3 August 2021

Residential Development at 89 John Whiteway Drive, Gosford (SSD-10321)
Request for additional information

Teresa Gizzi
Team Leader, Regional Assessments

1 CUT AND FILL DIAGRAM - IMPACT ANALYSIS PLAN  
DA003.1 1:500

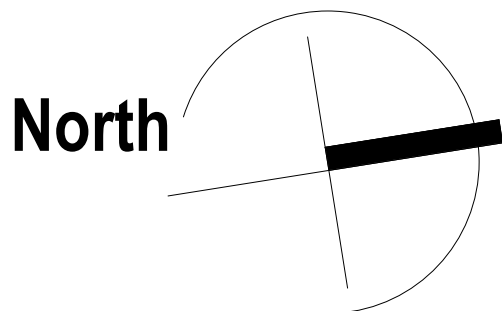
The Department requests further clarification on areas of excavation across the site. Further details of cut and fill across the site is required, clearly identifying areas of excavation, existing and finished ground levels, as well as RL's beyond the excavated area. This detail must be shown on a cut and fill plan, as well as section plans, showing the extent of excavation across the site, including to the following areas:

- Eastern boundary adjoining units C1-05 to C1-08.
- The proposed landscaping area adjoining the western side of the communal swimming pool (Drawing No. 10-19.32), which encroaches beyond the non-buildable area.

Please find attached an annotated drawing, identifying the locations of the requested sections in red. Please ensure the level of detail within the section plans is similar to that provided on pages 5-7 of your recent submission, prepared by Distinctive Living Design. This information is sort by the Department, to understand the level of cut and fill, extent of the batter, treatment of the batter and any associated impacts on residential amenity.
